**From:** Olson, Greg  
**Sent:** Wednesday, February 19, 2014 2:17 PM  
**To:** 'G Robert Adams'  
**Cc:** 'Leslie Ford'; Biazar, Shahab; Olson, Greg; 'Perry Hassell'  
**Subject:** A11-E011B Erosion & Sediment Control Plan for McDonalds at McMahon Marketplace - PE Seal 12-20-2013

The 12-20-13 plan is cannot be approved, primarily because the disturbed area on the north side of the site needs to be expanded to include the pond outfall pipeline construction corridor.

CE

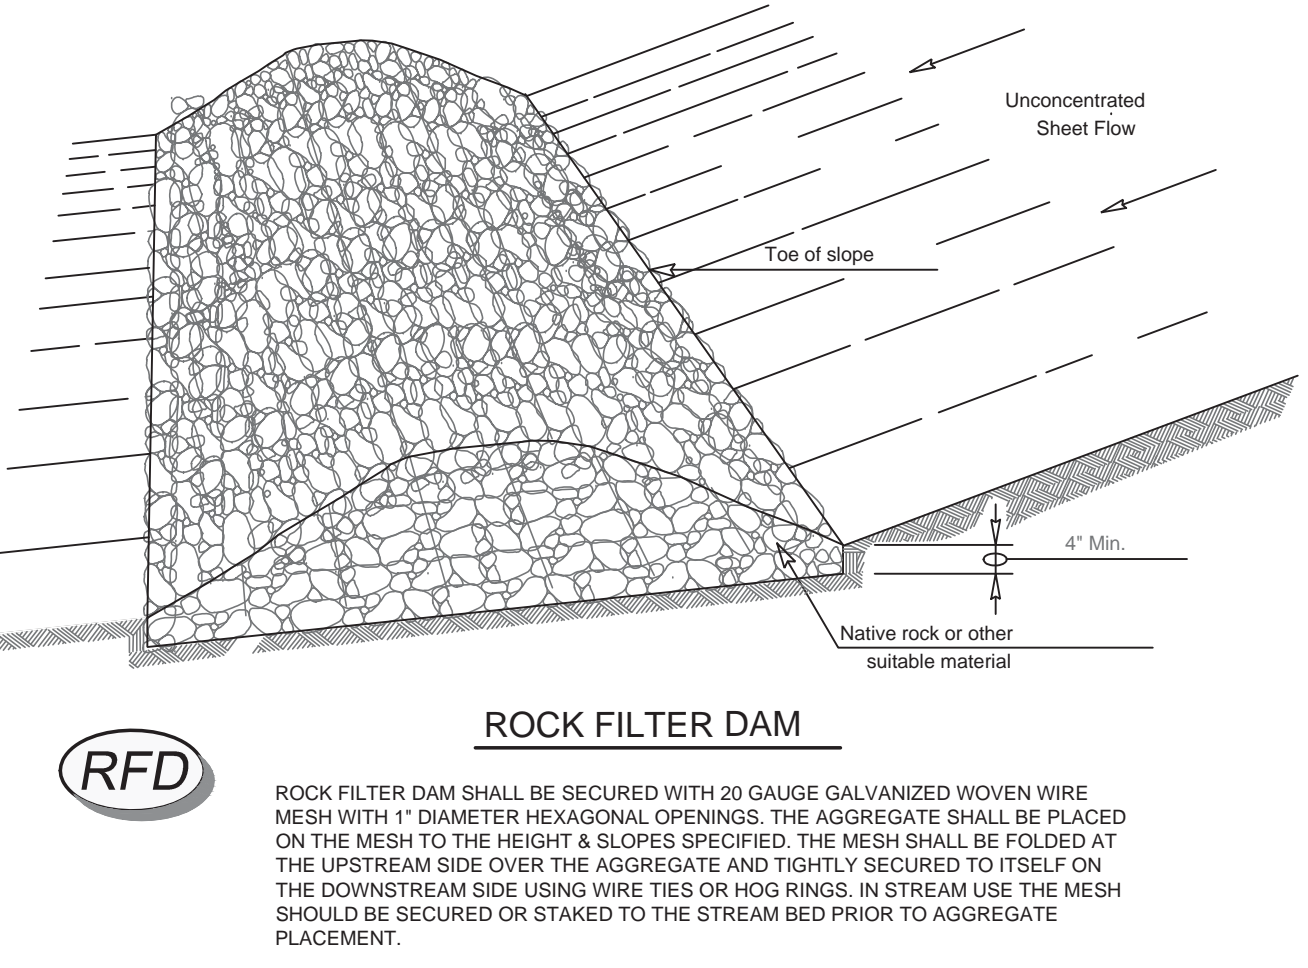
1. The minimum acceptable length for the construction entrance is 50'. Your BMP detail refers to the plan dimensions, which were not provided. Specify width and length (50' min.).
2. Include an **"Erosion Control Maintenance Note"** which requires that sediment off-tracking be monitored continuously, and any sediment tracked or blown onto Public streets or R/W shall be promptly removed, but in no case more than 24-hours after the erosion.
3. Two sections are labeled " **\*\*\* CAUTION: NOTICE TO CONTRACTOR \*\*\*** " and if not duplicate, may conflict.
4. The pond outlet structure may also need "Curb Inlet Protection" or a similar BPM when added to the G&D plan.
5. Identify the location on the plan for the site SWPPP information sign.
